Your ref: SSD-10395
File no: MC-19-00006

**SSD-10395 – Proposed Energy and Resource Recovery Centre at 339
Wallgrove Road, Eastern Creek**

Blacktown City Council submission to exhibited proposal for an Energy and Resource Recovery Centre at 339 Wallgrove Road, Eastern Creek (SSD-10395)

Figure 3-1: Proposal setting and assessed receptor locations

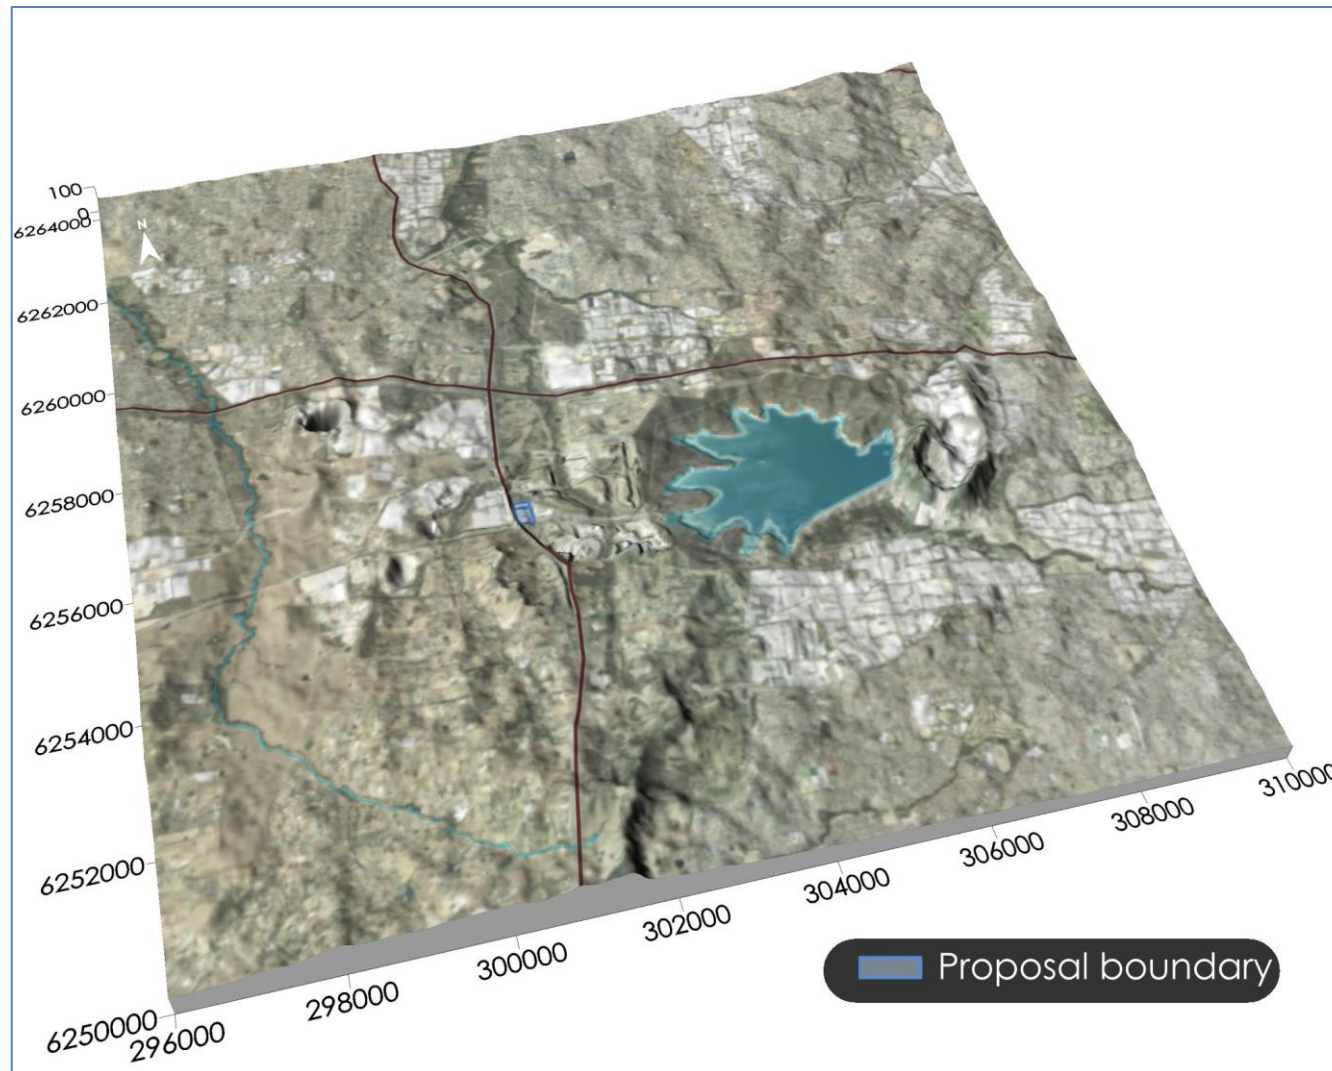
- *“The analysis has focused on the assessment locations which represent the closest and most likely impacted receptor locations surrounding the proposal and are a mix of residential, commercial and industrial receptors.”* (S7.2.1 page 78)

There is no analysis for the impacted residential receptor locations in Minchinbury and Erskine Park. This analysis should have been undertaken by the proponent as part of the EIS and the EIS is flawed because of this omission. The residents of these locations should have information to understand the impact it will have from their receiver distance.
 - *“The flue gas cleaning systems will be operational and are expected to mitigate the release of air pollutant in the flue gas during start up and shut down procedures. Other emissions are expected to be controlled by proper combustion conditions.”* (S7.4 page 81)

Figure 8-2: Flue gas cleaning system

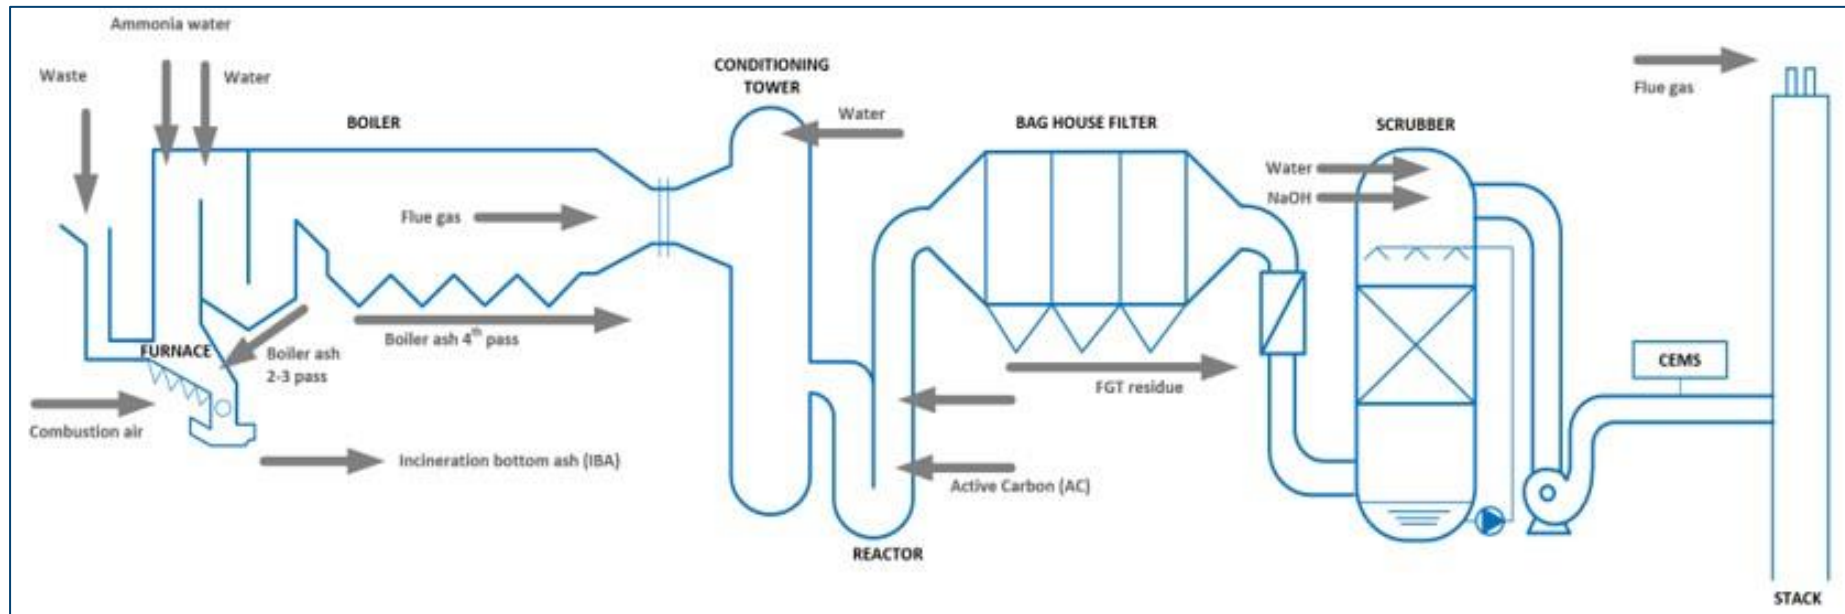
The applicant is to explain how this ‘expectation’ is a realistic mitigation measure. Further clarification is required on the technology chosen for the flue gas cleaning system, and if it will also be available/operational for unexpected shut downs or faults within the process to ensure all emissions are controlled.
 - *“Incinerator Bottom Ash (IBA) remaining after the combustion process is discharged into a water bath and quenched ... the residual bottom ash is securely stored before transported off-site for recycling or disposal at a licensed facility. Ash residue will be handled in sealed conditions within the facility.”* (S8.5 page 89)

Figure B-1: 24-hour average PM<sub>2.5</sub> concentrationsFigure B-2: 24-hour average PM<sub>10</sub> concentrations

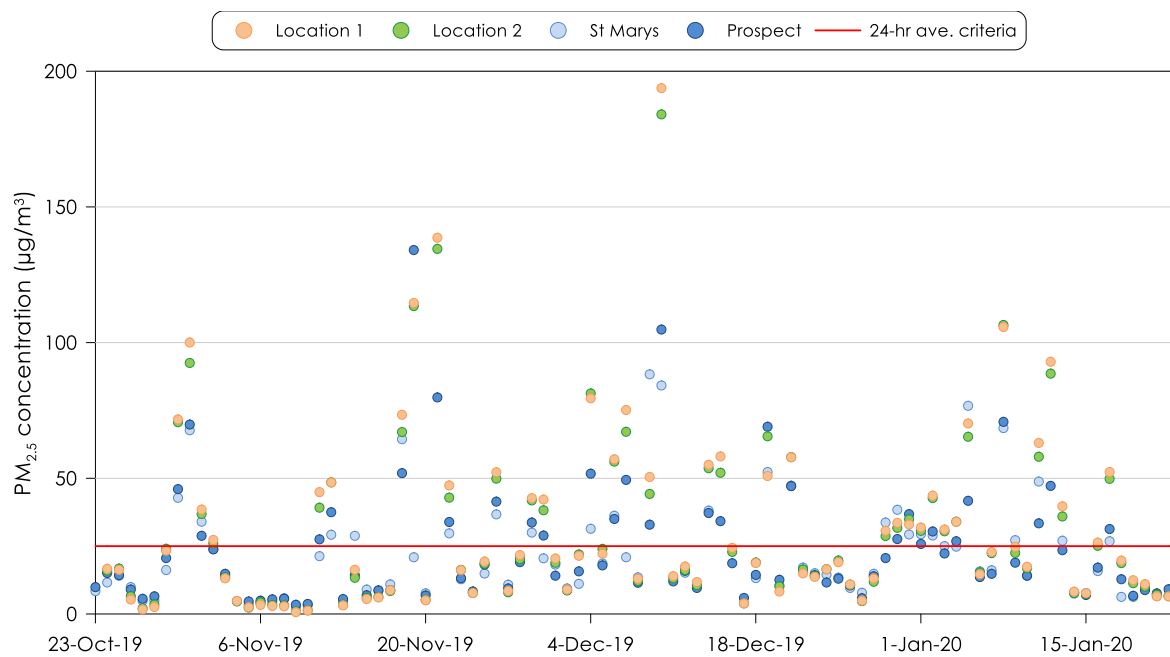
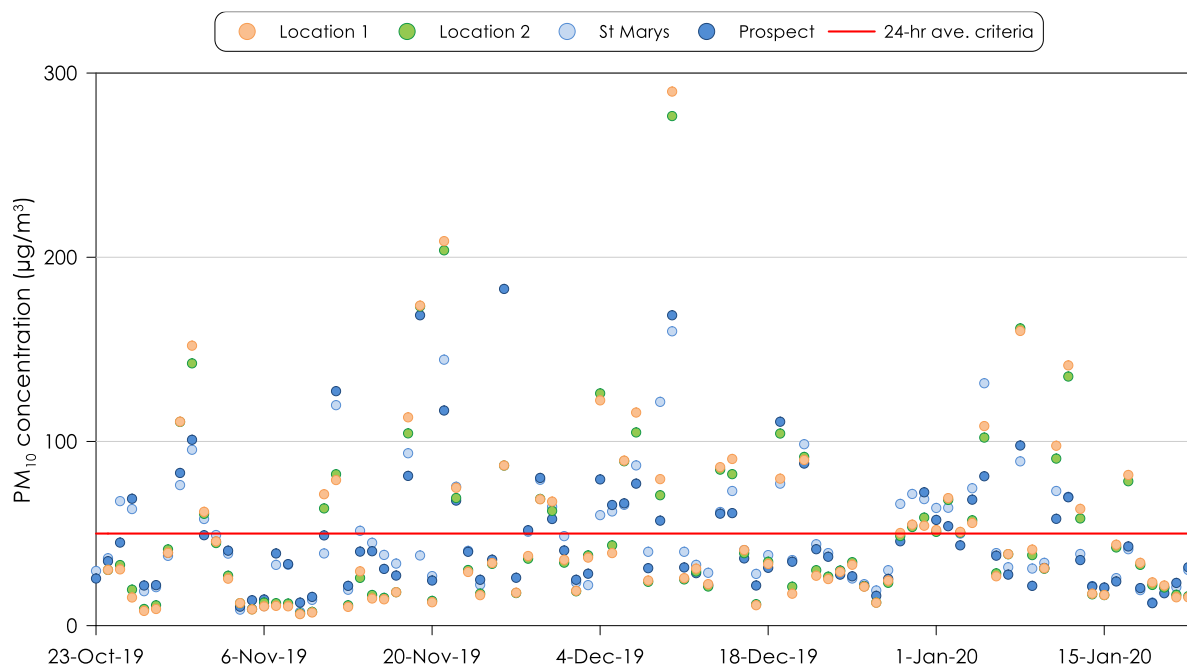
- “Ambient air quality monitoring near the proposal was commissioned for a three-month campaign from 23 October 2019 to 23 January 2020.” (page 30)

The applicant is to explain why this date range was used for the campaign, when bushfires would attribute to elevated particle levels.
